Rezoning Petition Review

Date of Review: August 27, 2020

Rezoning Petition #: 20-99

Location of Property: Approximately 20.88 acres located along the southeast side of Mallard Creek Rd and north of Morris Estate Dr.

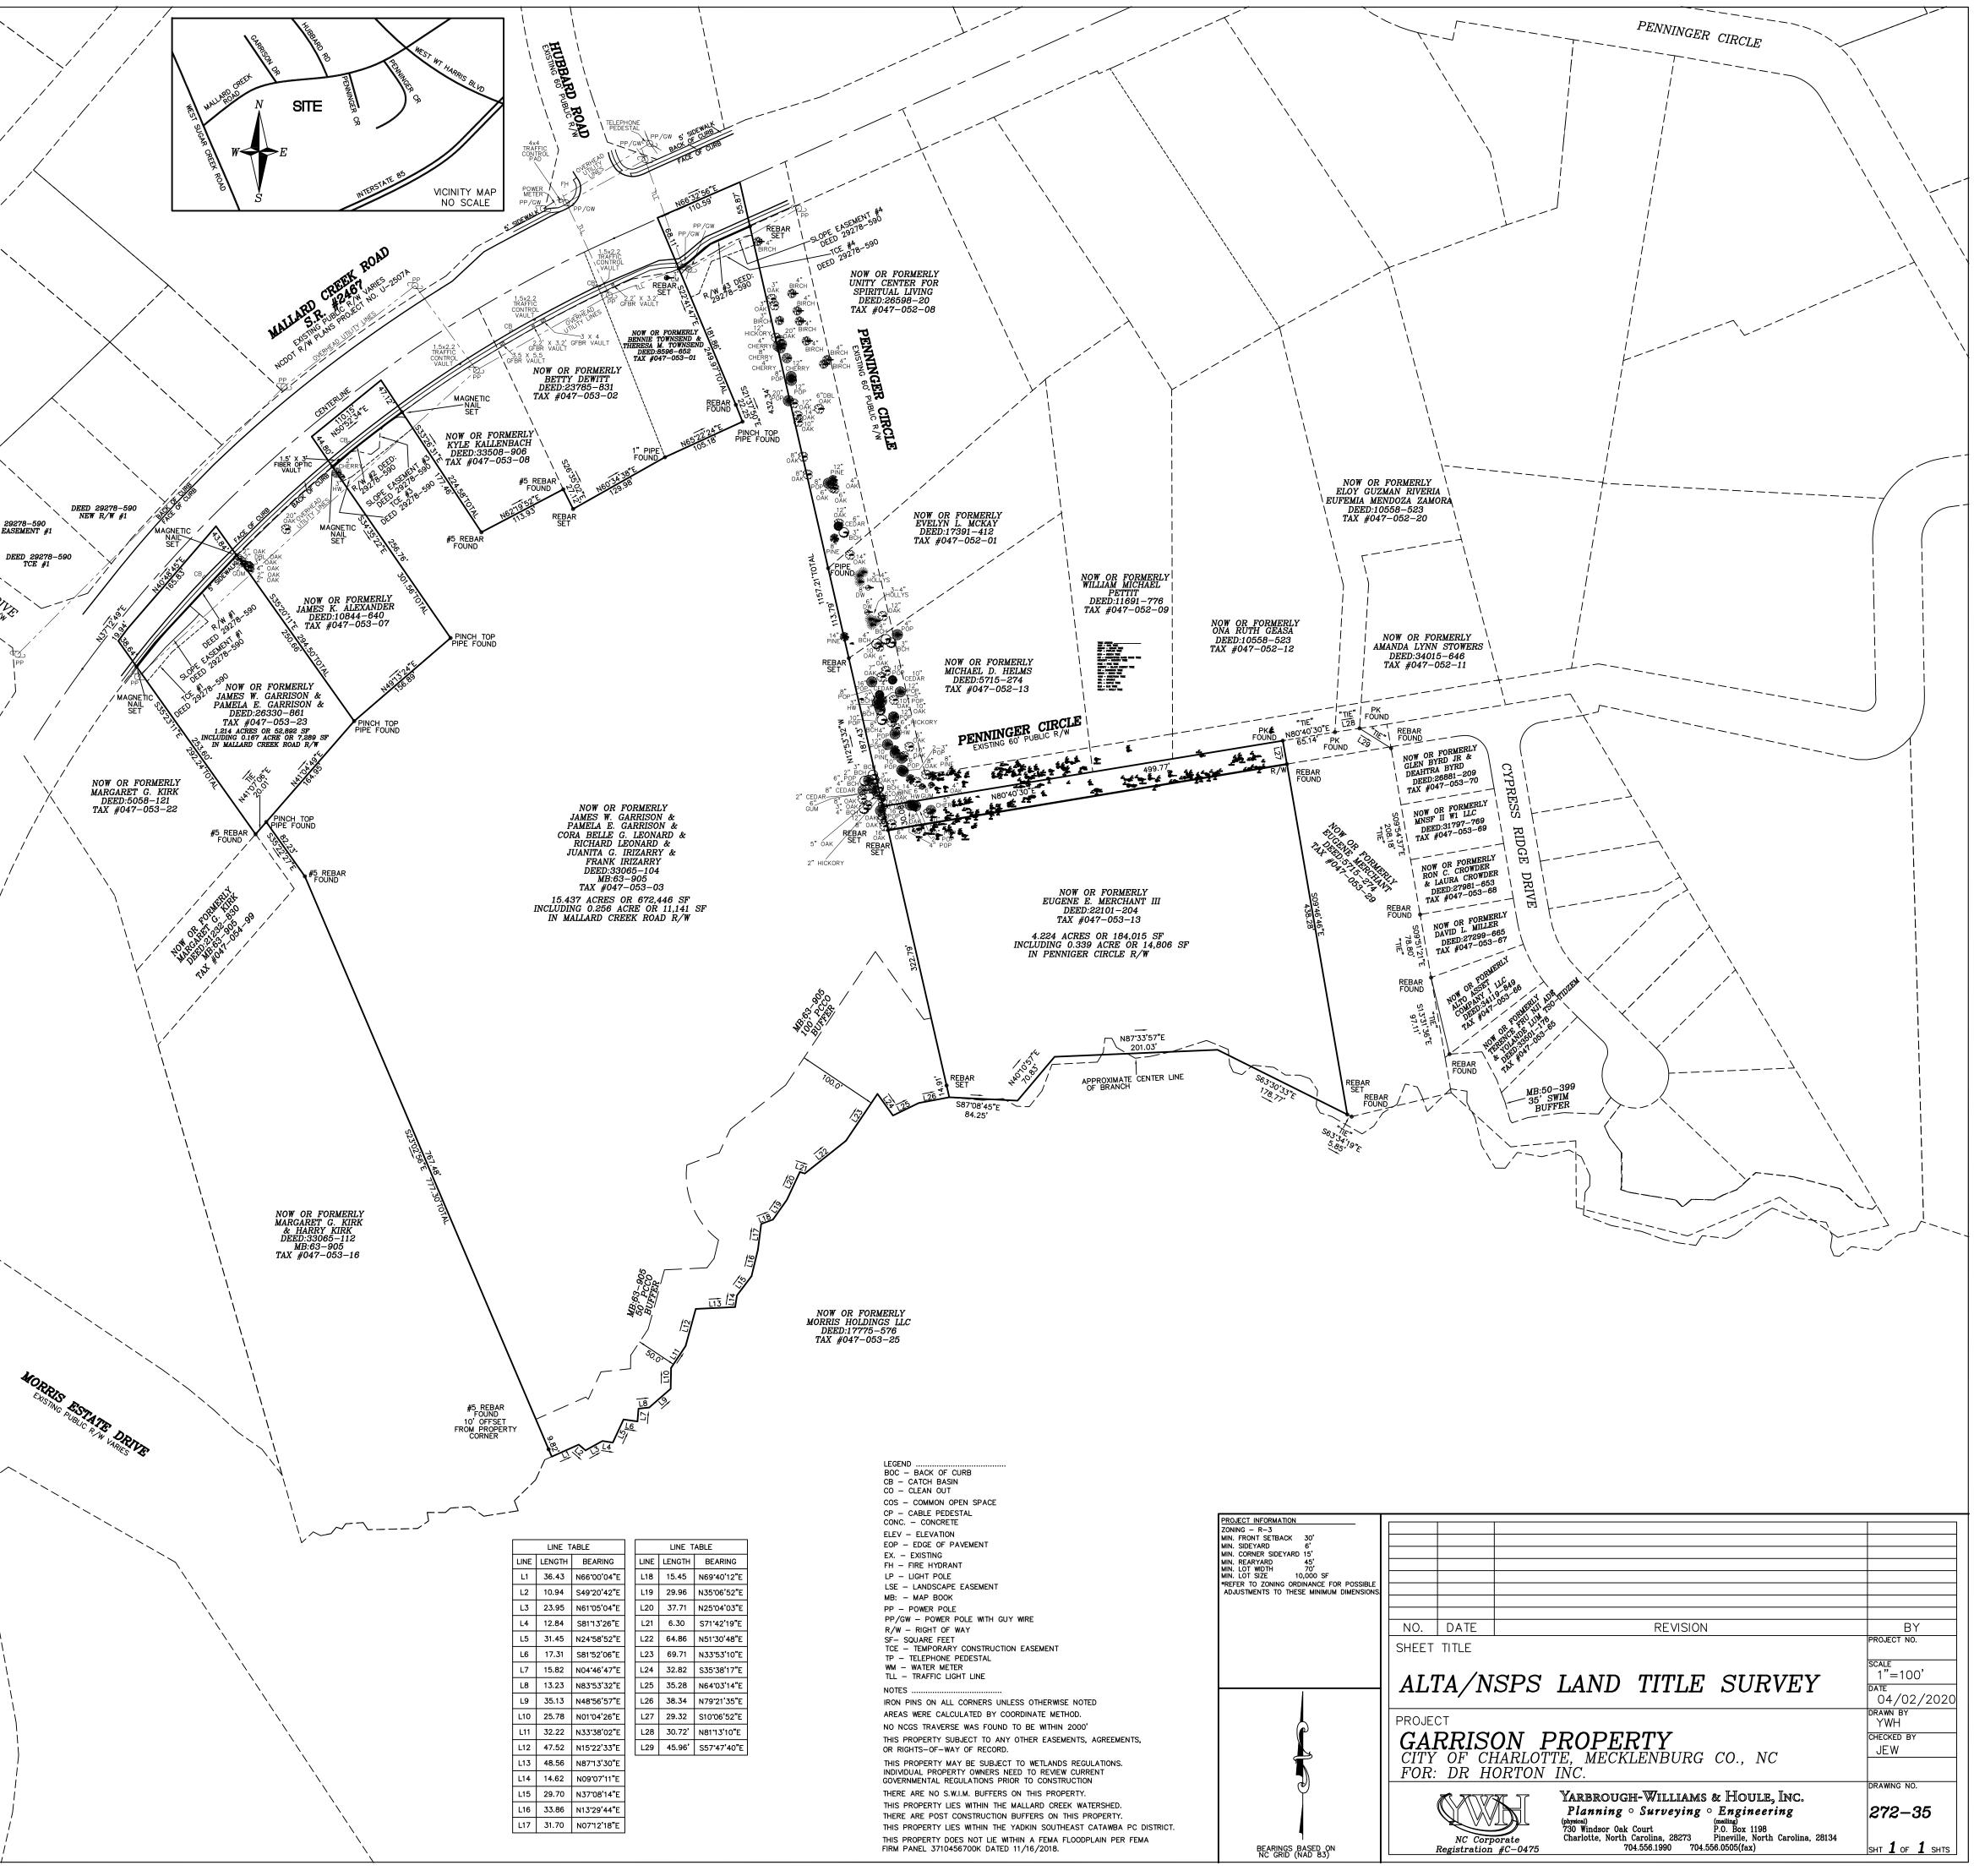
Concerning Storm Water: Please revise the label reading *50' Water Quality Buffer* and *100' Steam Buffer* to read *50-ft Undisturbed PCSO Buffer* and *100-ft Undisturbed PCSO Buffer*.
